Subject: Response to Submissions - Yiribana Logistics Estate (SSD-10272349)

Attachment 1: Environment and Heritage Group comments in relation to proposed stormwater management strategy for Yiribana Logistics Estate (SSD-10272349)

SSD-10272349 – Response to Submissions for Yiribana Logistic Estate

STORMWATER DRAINAGE MASTER PLAN
SCALE 1:1000

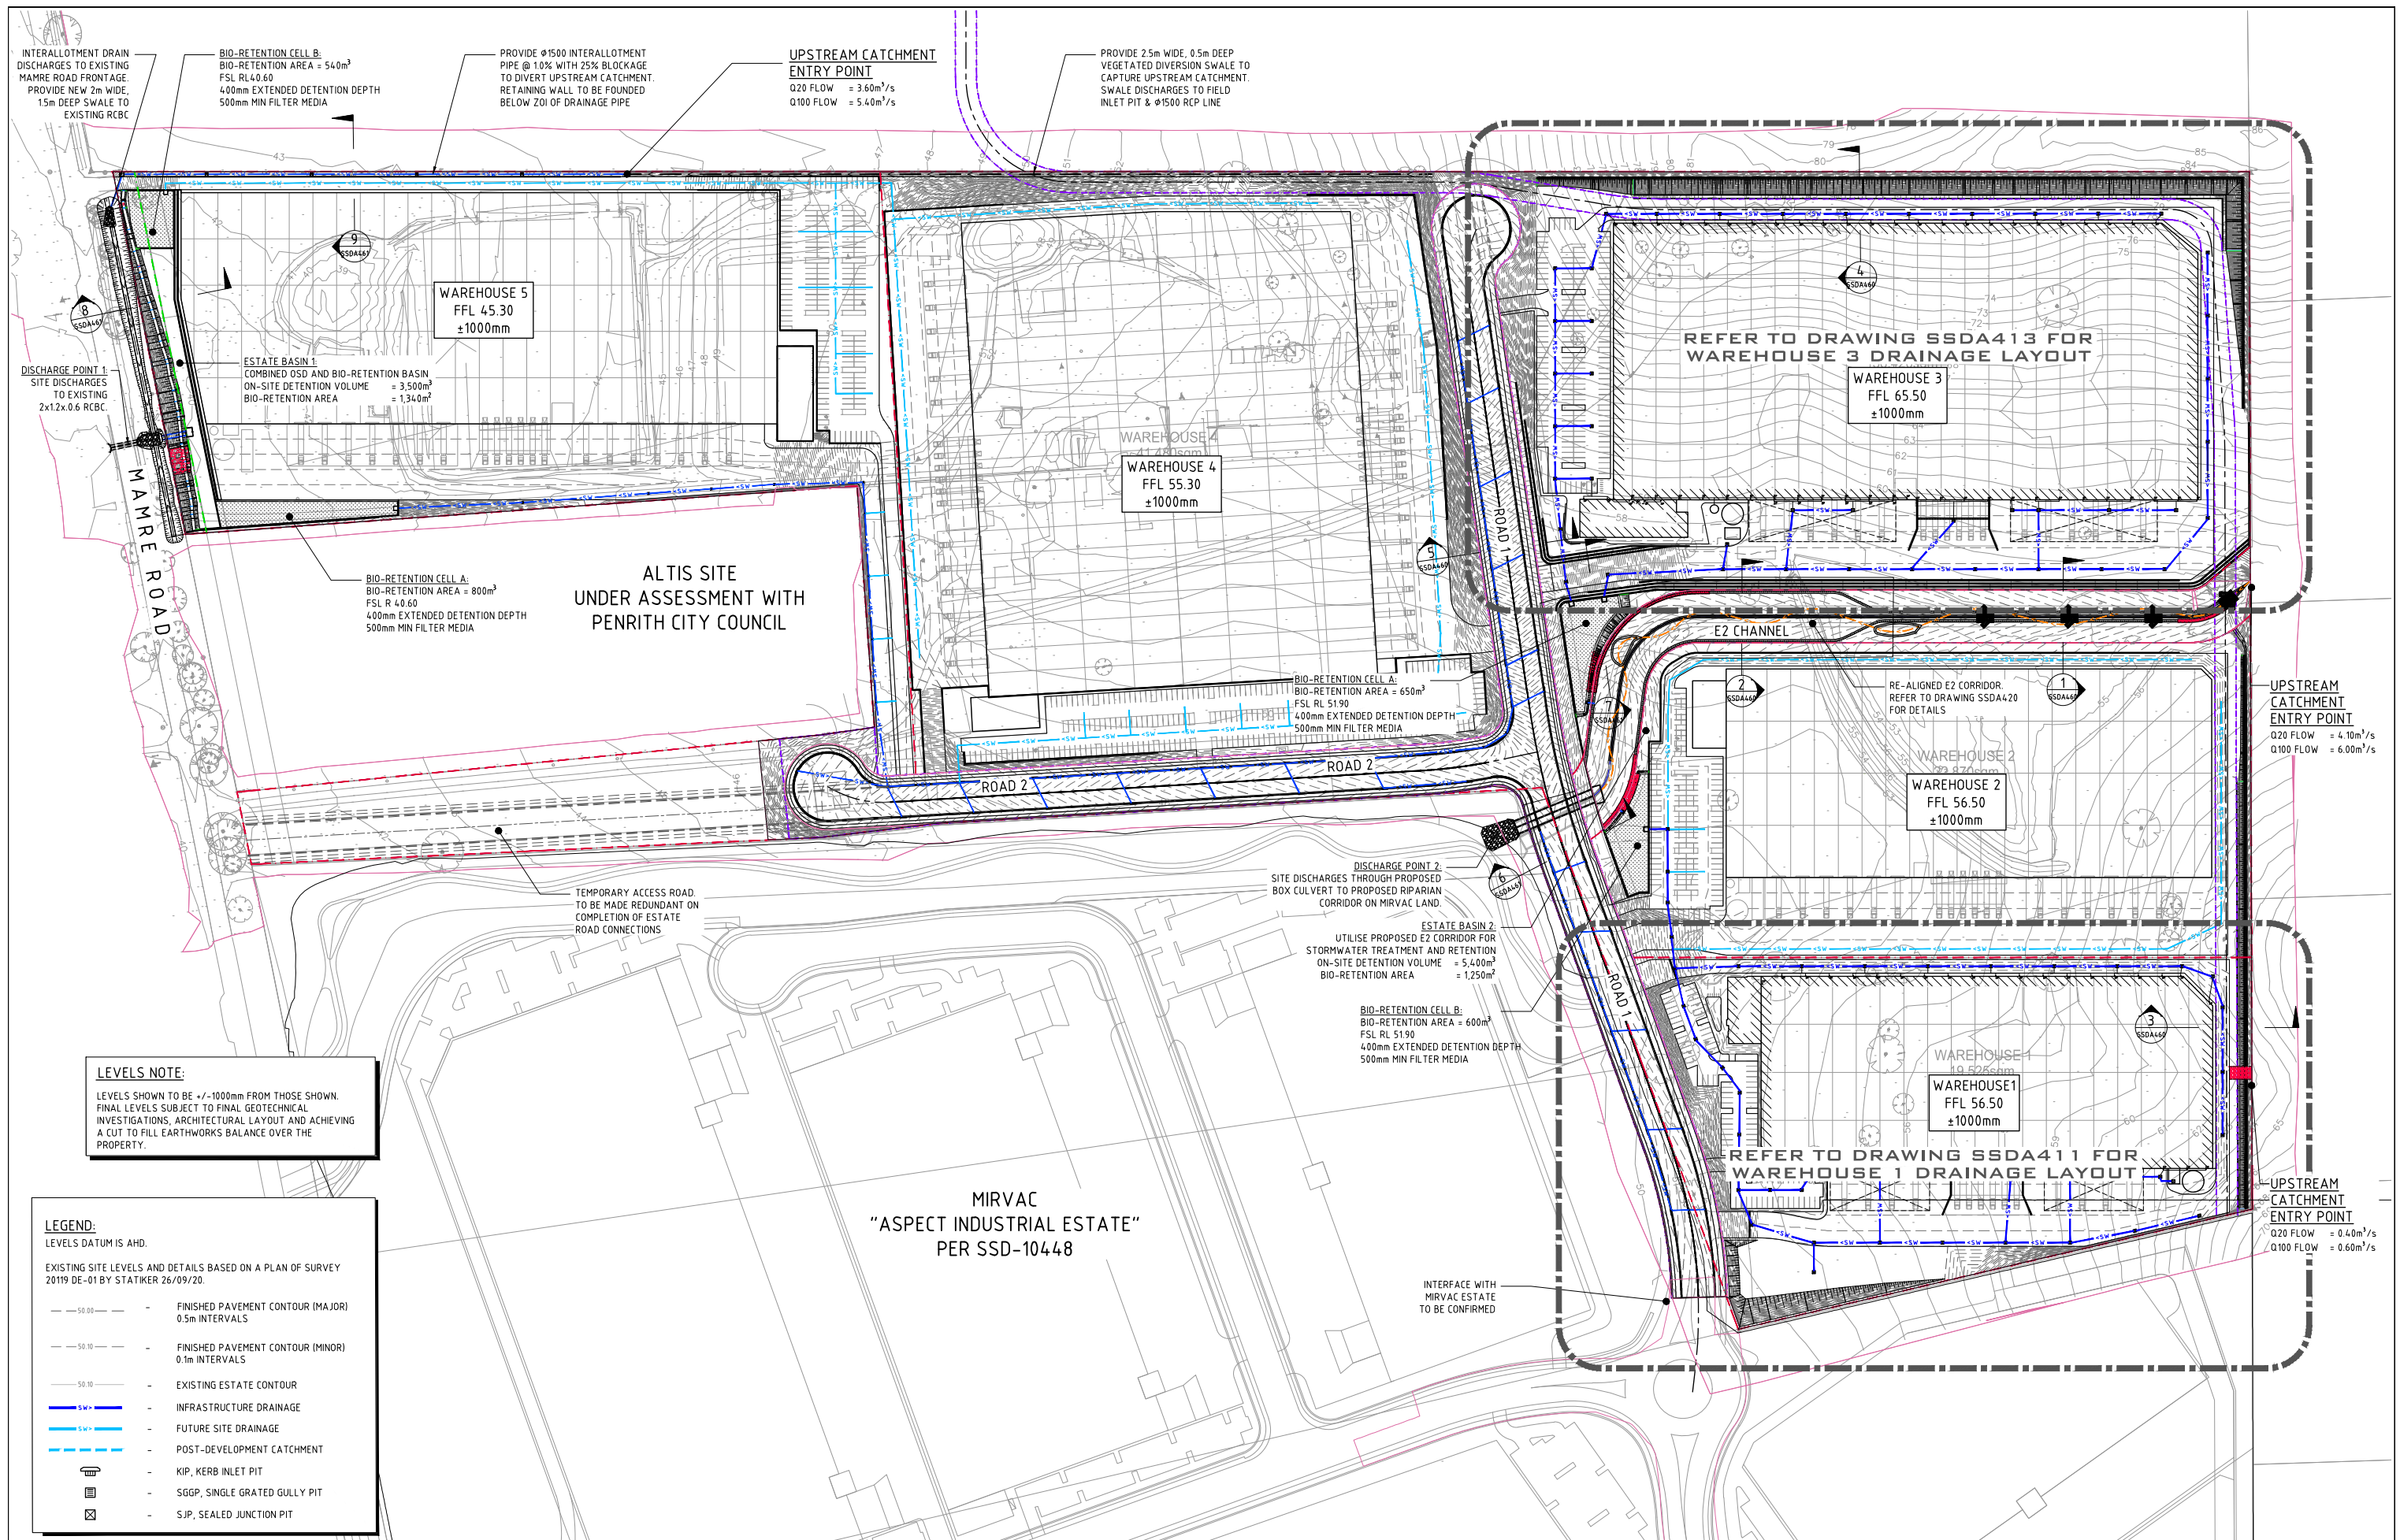
No catchment/WSUD plan or table has been included in the reporting. A plan and table must be provided showing:

- all catchments and land use splits (and areas/% impervious)
- drainage locations and any flow diversions/splits
- WSUD systems
- proposed irrigation areas for tanks and ponds.

E2 CORRIDOR ALIGNMENT PLAN
SCALE 1:500

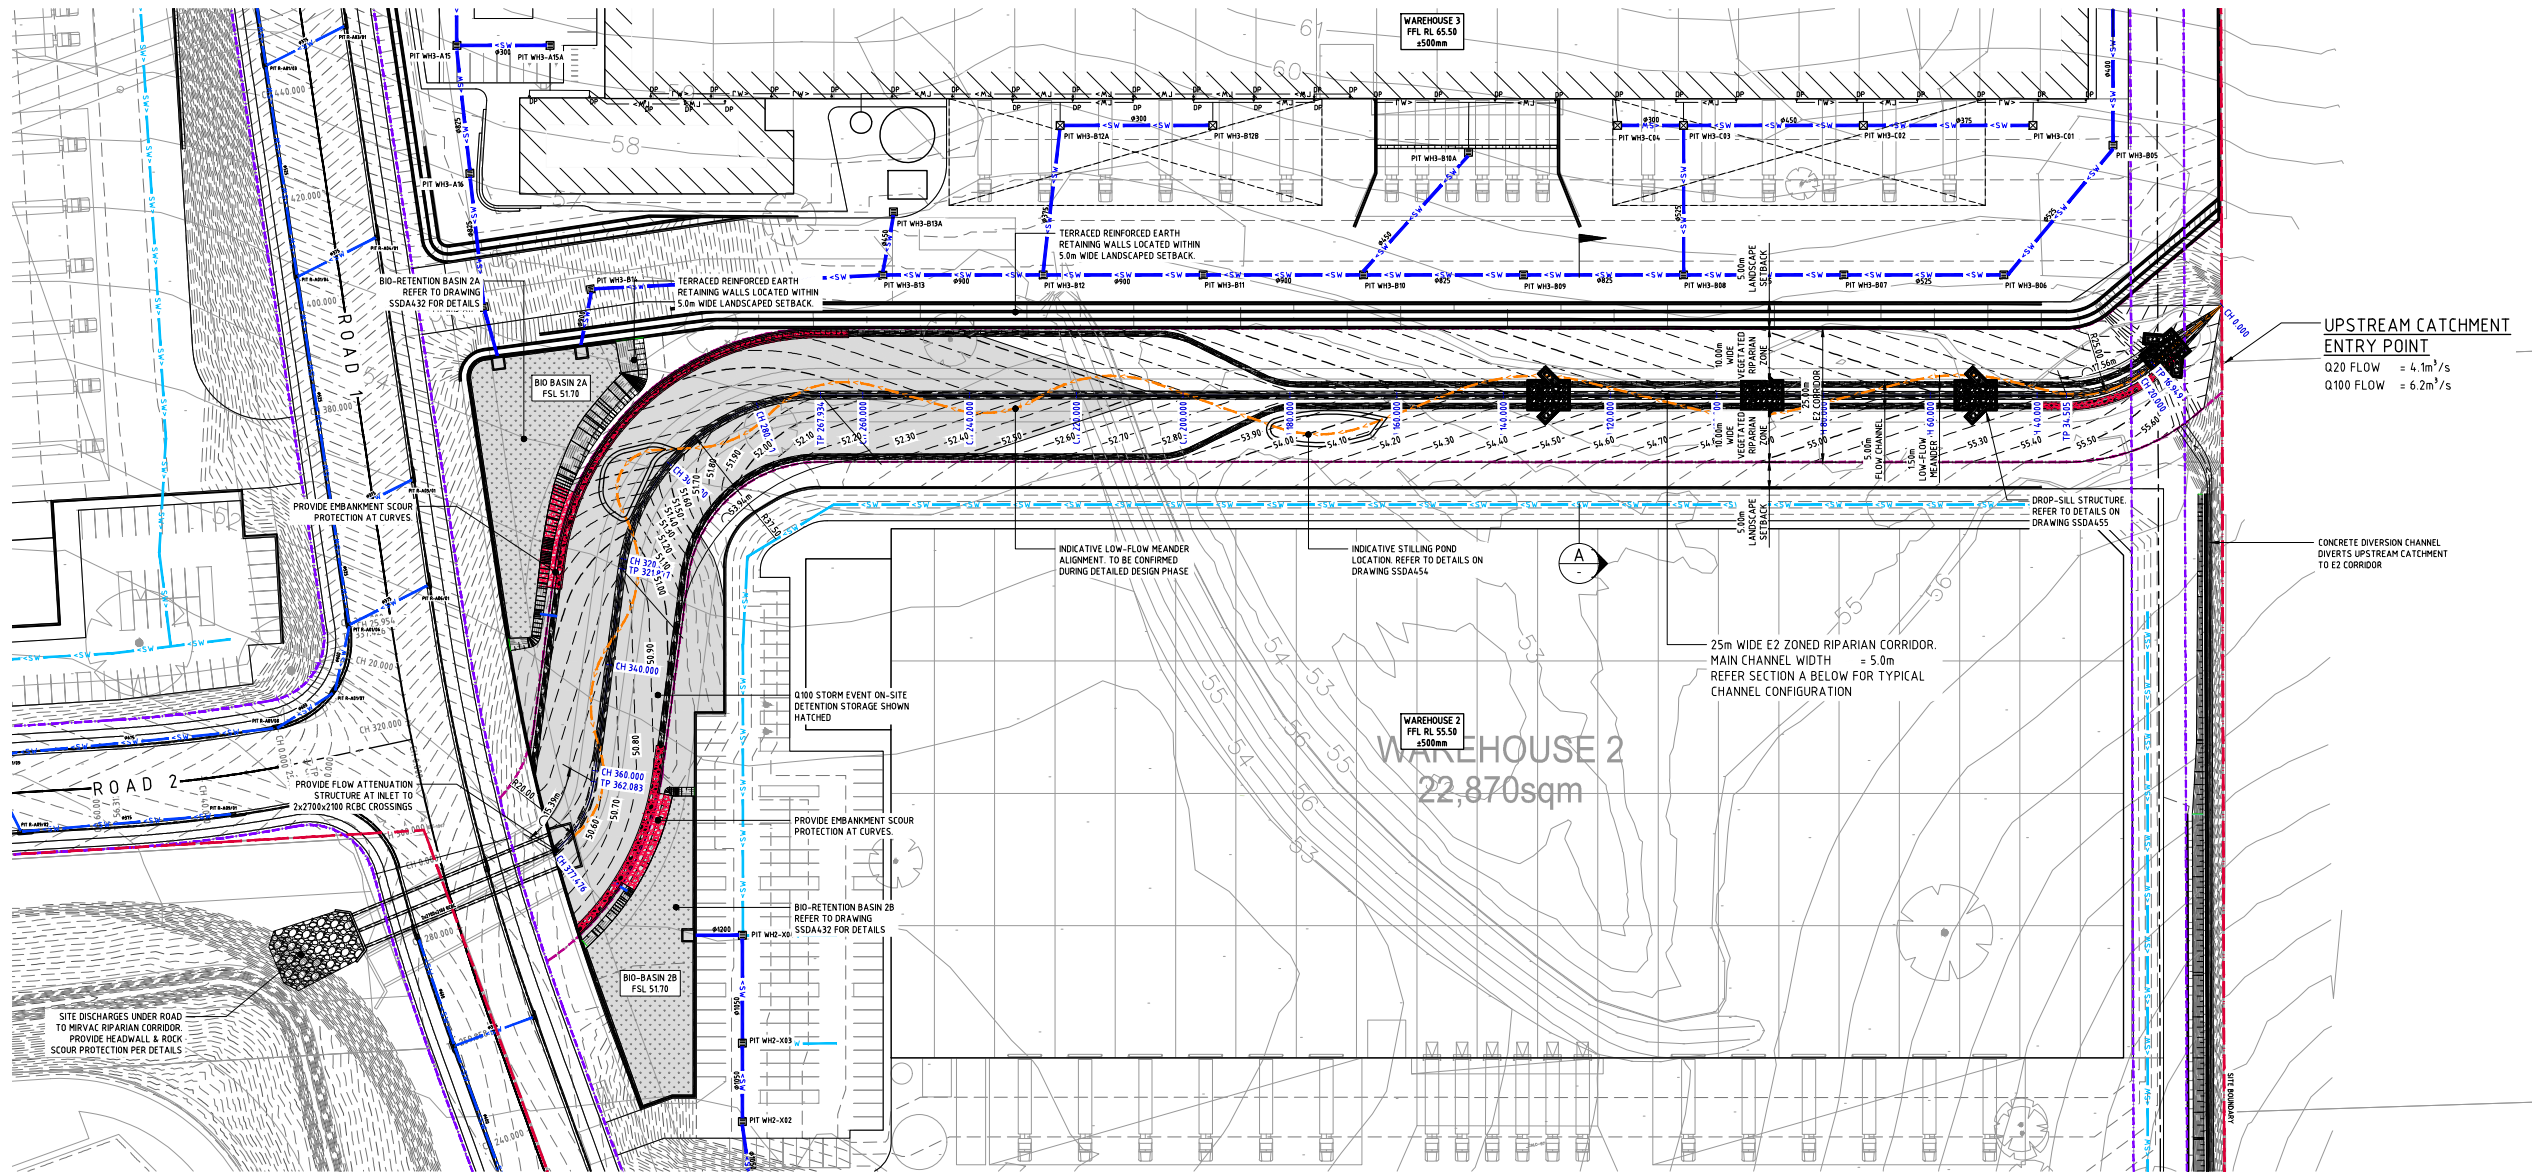
Plans are notated with '*Proposed E2 Riparian Zone*'. It is unclear what this means.

The applicant is to clarify if the statement '*Proposed E2 Riparian Zone*' relies on a re-zoning from IN1 General Industrial to C2 Environmental Conservation under SEPP (Industry and Employment) 2021 and is to fully describe the process proposed to be undertaken to achieve such.

It is recommended that the landscape setback fencing located at the bottom of the corridor is to be deleted as this poorly impacts fauna movement and serves no understood purpose, noting that fencing will also be required at the top of each side of the corridor retaining walls. All fencing shall be of open style (palisade, not chain wire/mesh) to allow free movement of fauna and to prevent reptile 'fence hanging'.
